Dean Spanos - RE: Ku-ring-gai Council Referral Letter - MP 10_0057 MOD 6

From: "Rebecca Hoschke" <rhoschke@kmc.nsw.gov.au>
To: "Dean Spanos" <Dean.Spanos@planning.nsw.gov.au>
Date: 4/20/2012 4:34 PM
Subject: RE: Ku-ring-gai Council Referral Letter - MP 10_0057 MOD 6

The Department of Planning and Infrastructure has received a Section 75W modification application from Karimbla Properties (No.4) Pty Limited to modify the approved Project Application at 132-138 Killeaton Street, St Ives (MP 10_0057 MOD 6).

BLOCK B ELEVATIONS

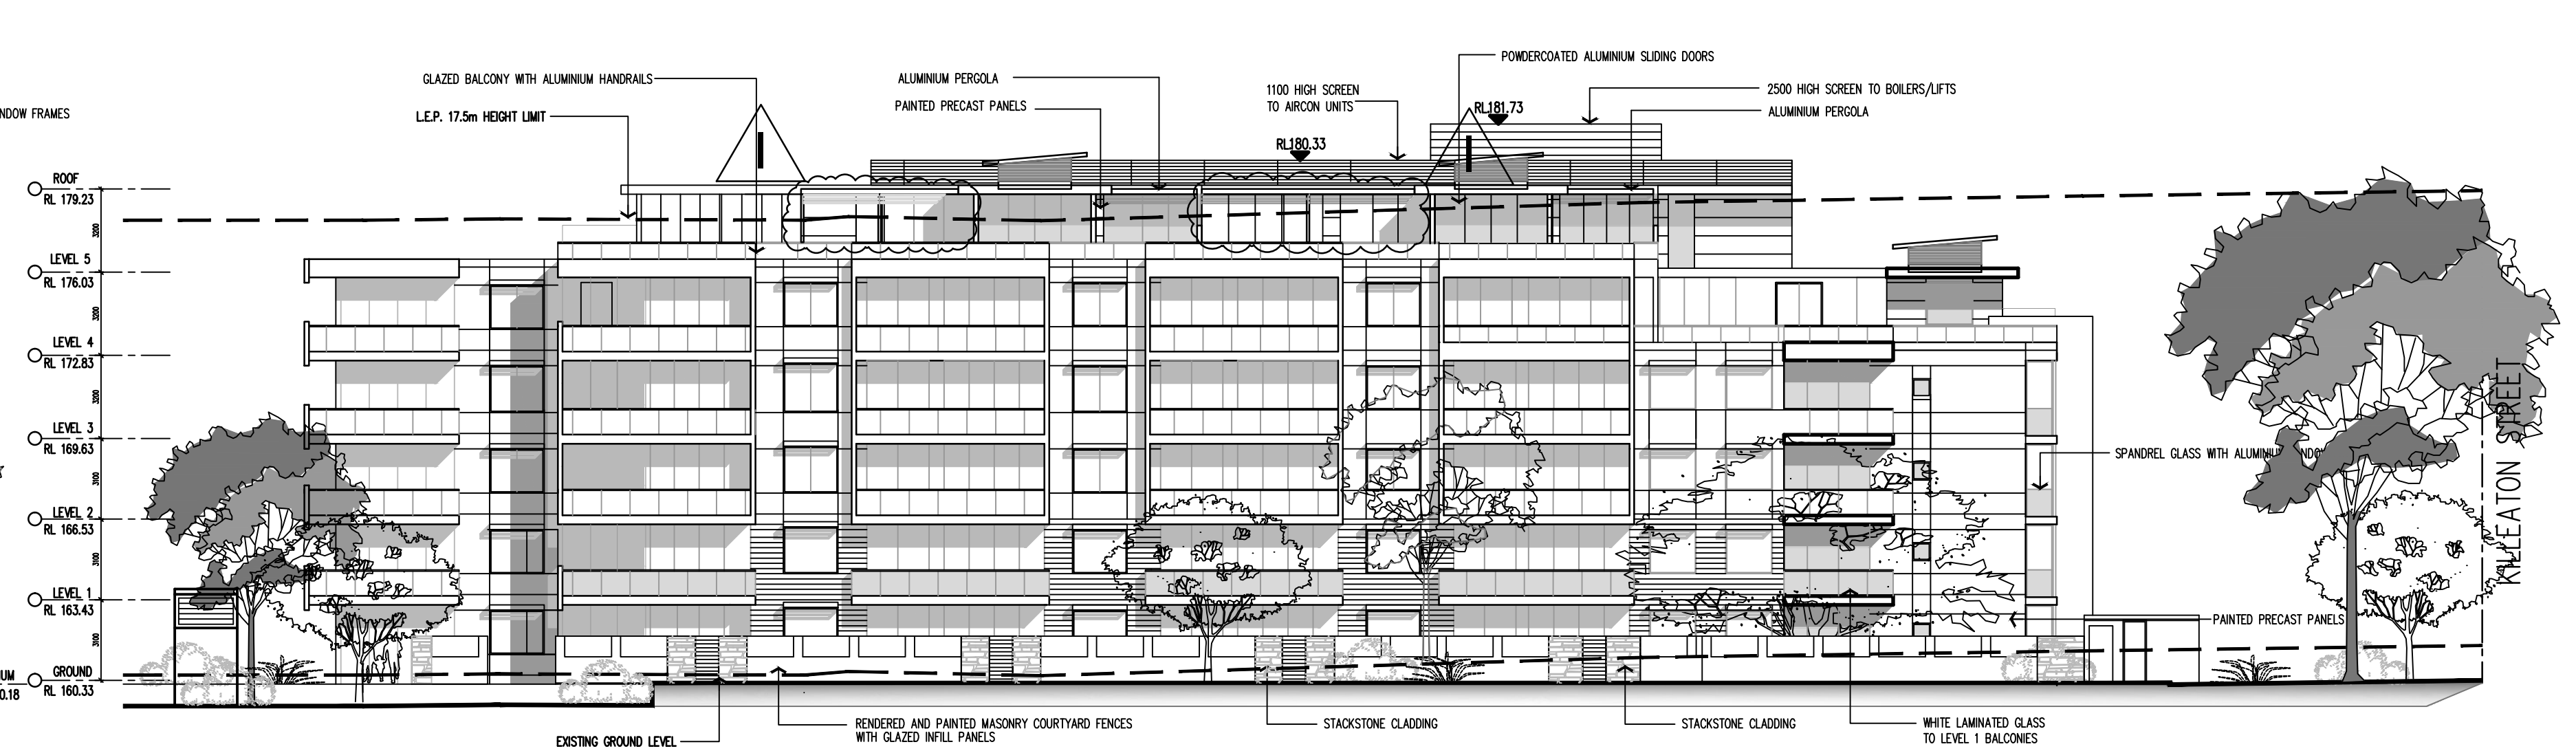
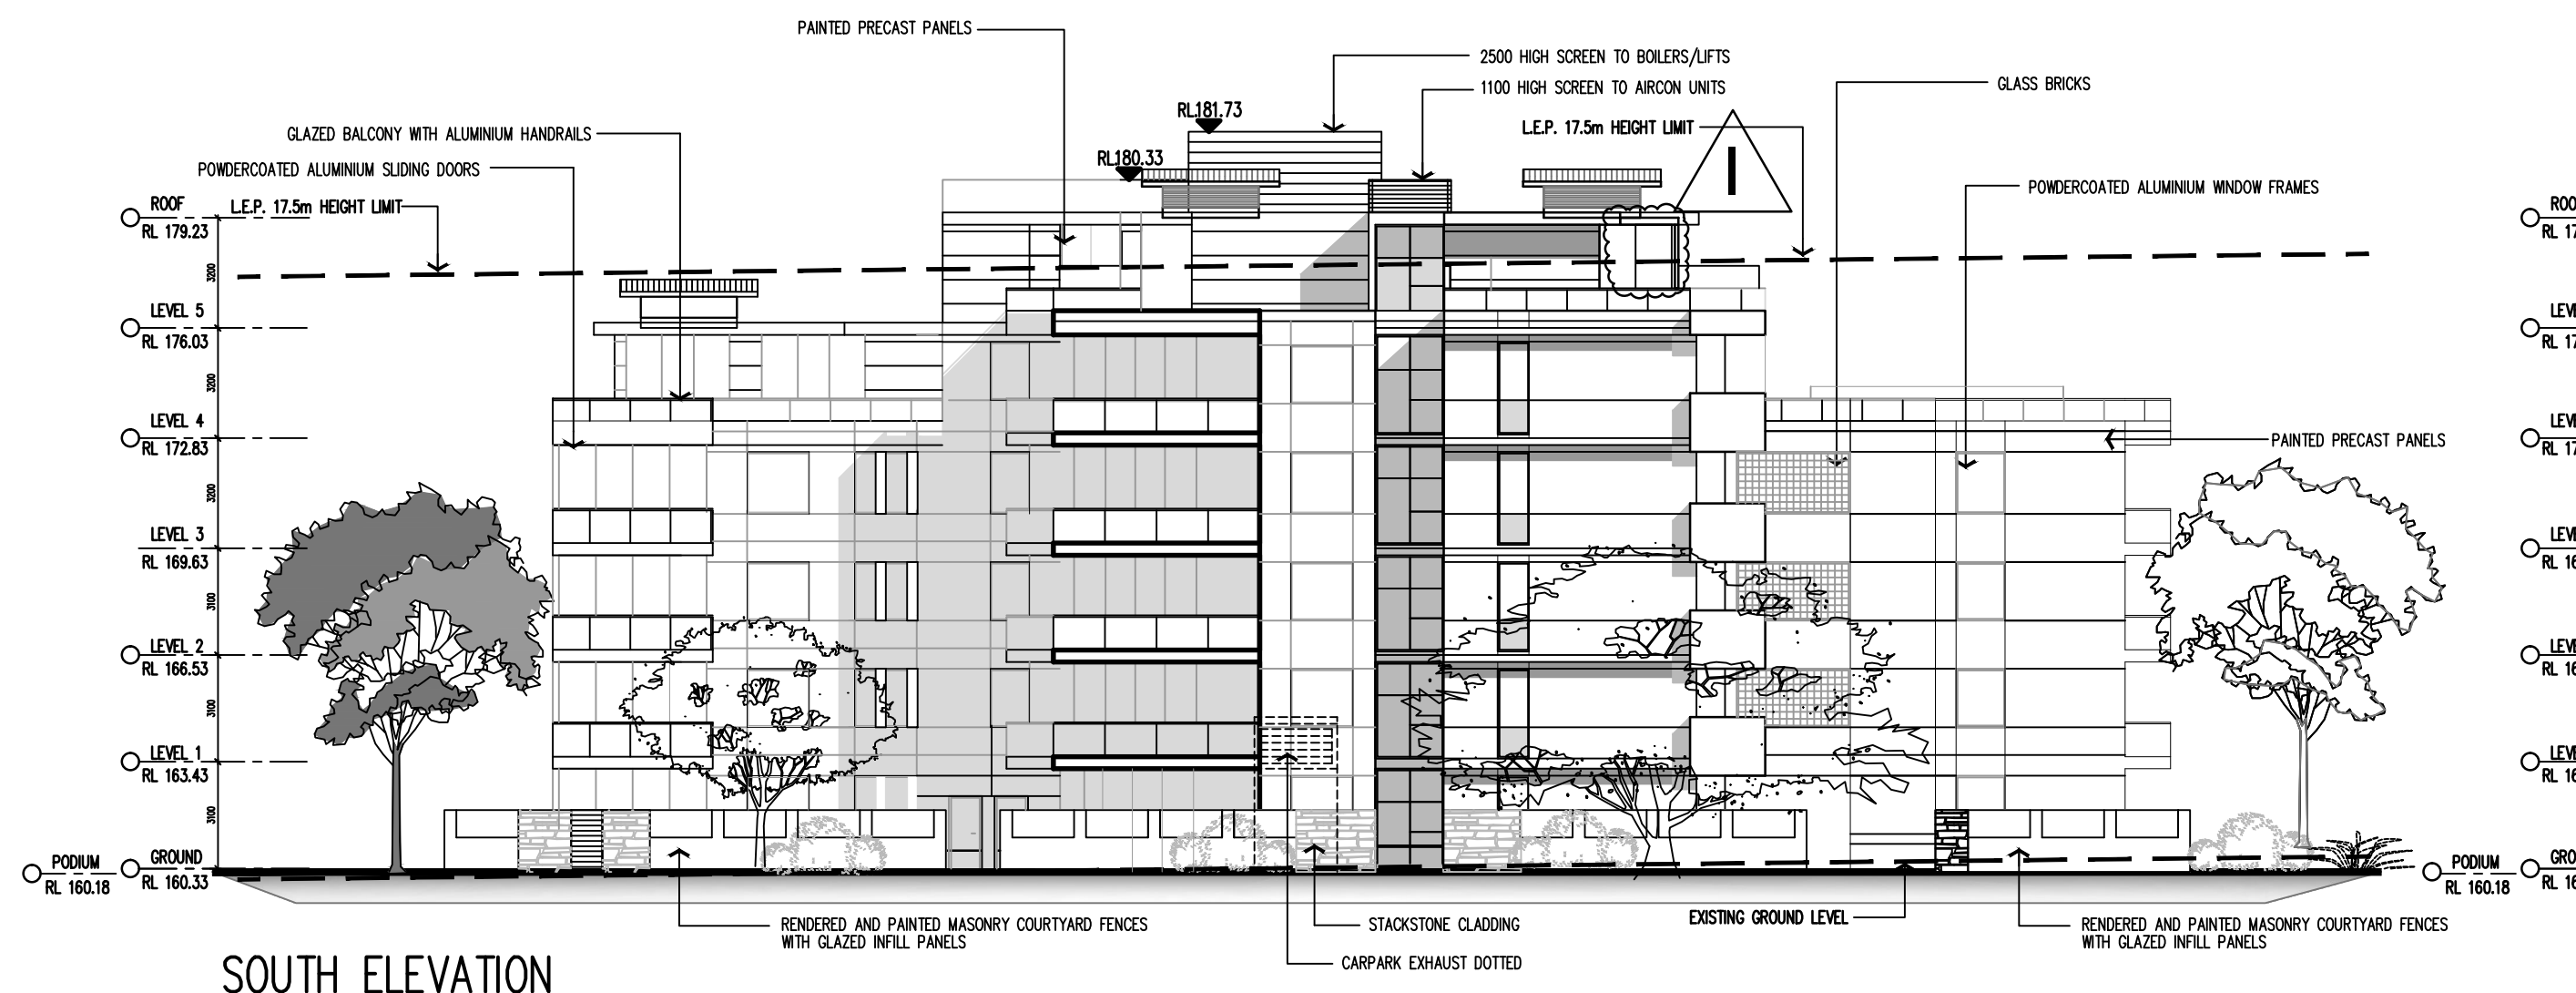
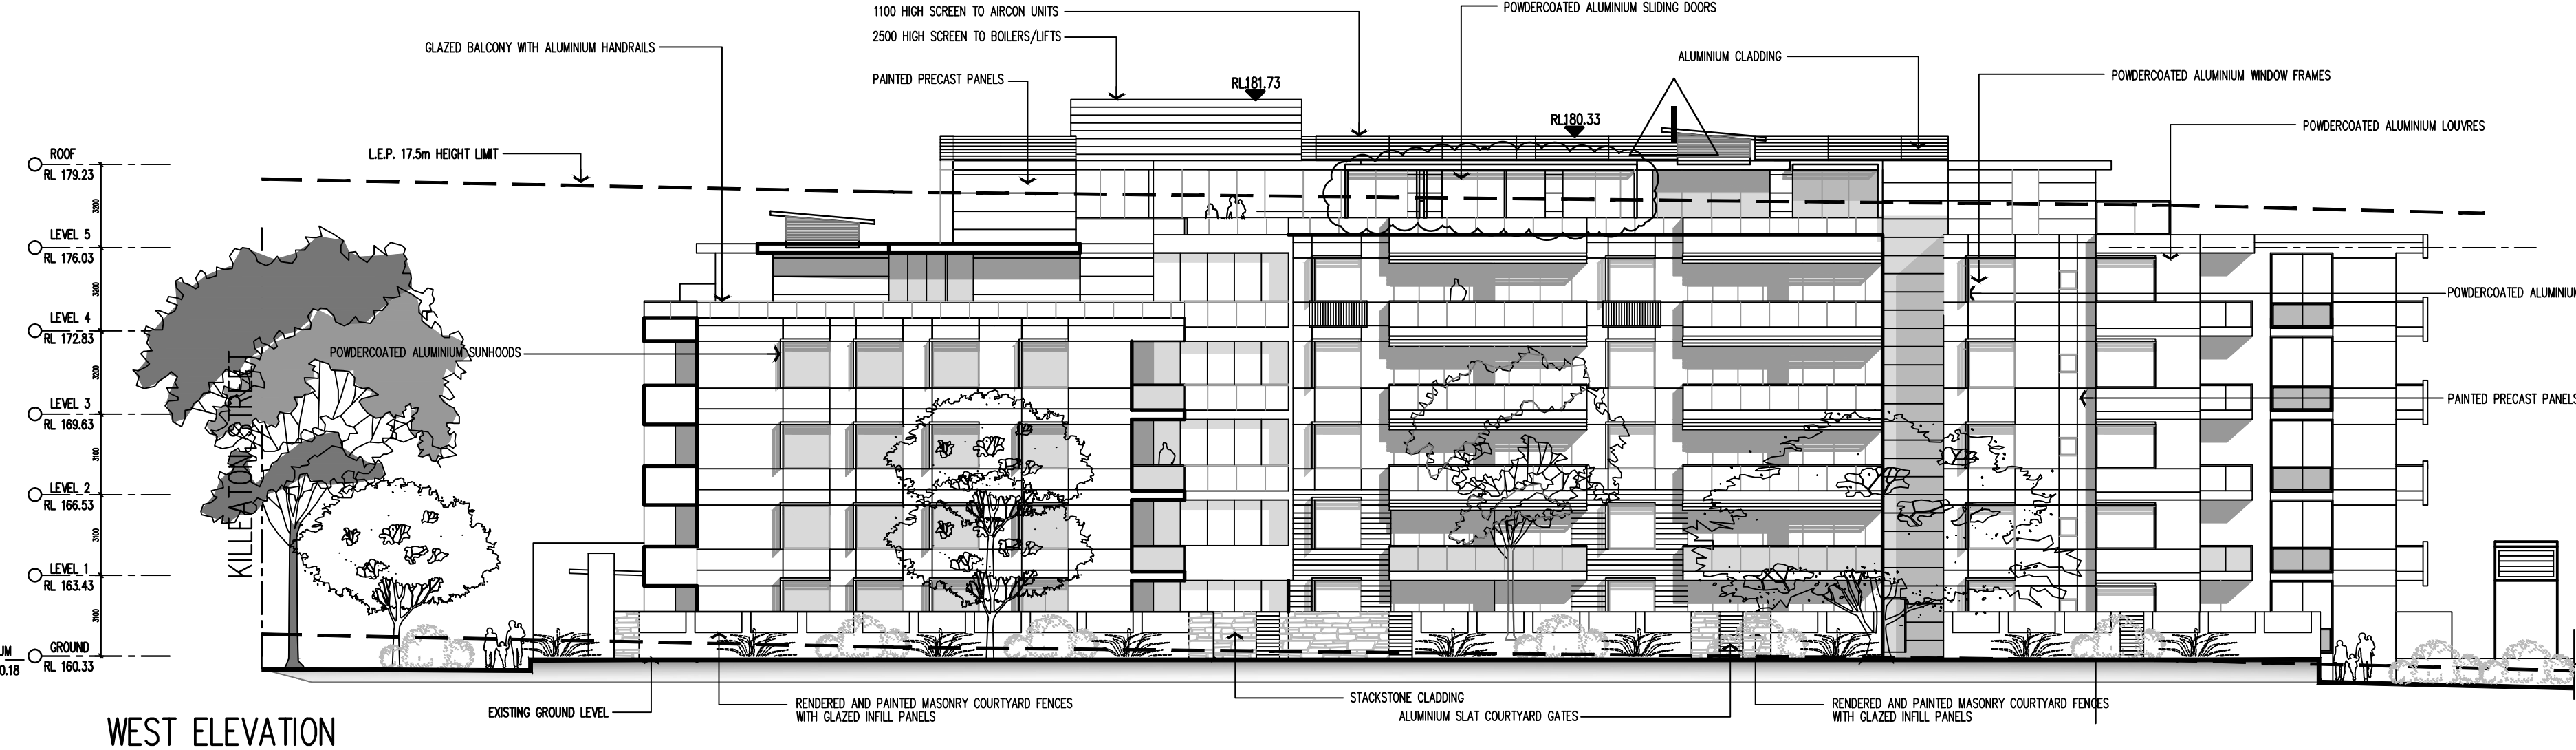
Generally, there are multiple pergolas which extend to the edge of the buildings and Council would not support (refer comments yesterday). It is recommended that the applicant recess and setback respective pergolas and that all such structures are light weight and open style.

Pergola structures to the edge of the buildings is not supported as recessing of the top storey loses its design intent. It is recommended that pergola structures be setback, preferably 1.5m-2m where possible.

Pergola structures must be of light weight material finish and open style to ensure the bulk, scale and design of the top storey remains relatively unchanged.
